KITITAS COUNTY

MEMORANDUM

SUBJECT: Keno SPF-19-00004

**KENO AGRICULTURAL SHORT PLAT
PART OF SECTION 29, T. 18 N., R. 20 E., W.M.
KITITAS COUNTY, WASHINGTON**

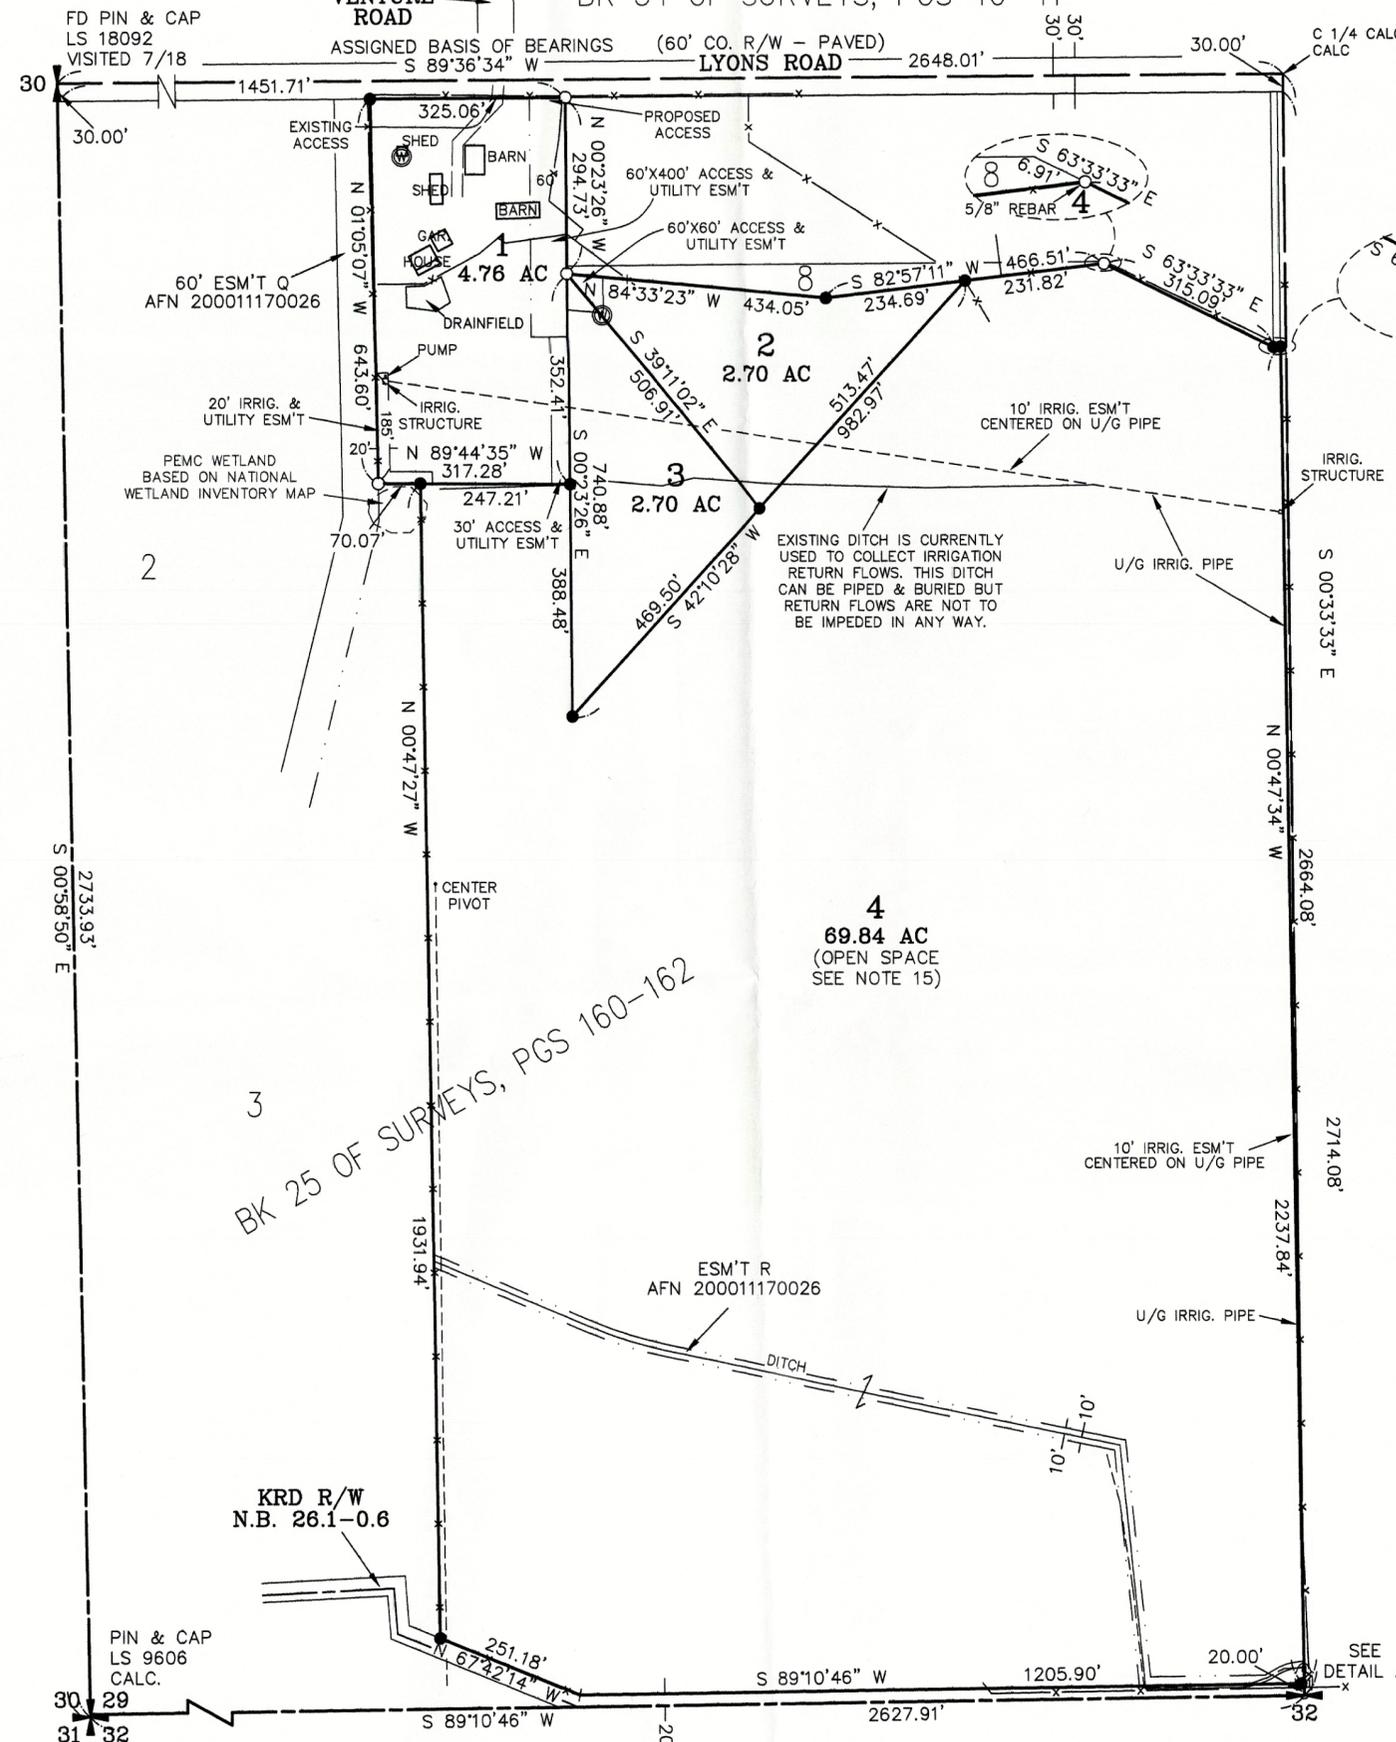
The 60' access easement on lot 1 shows a section of a barn inside the easement, creating a bottleneck in a portion of the easement.
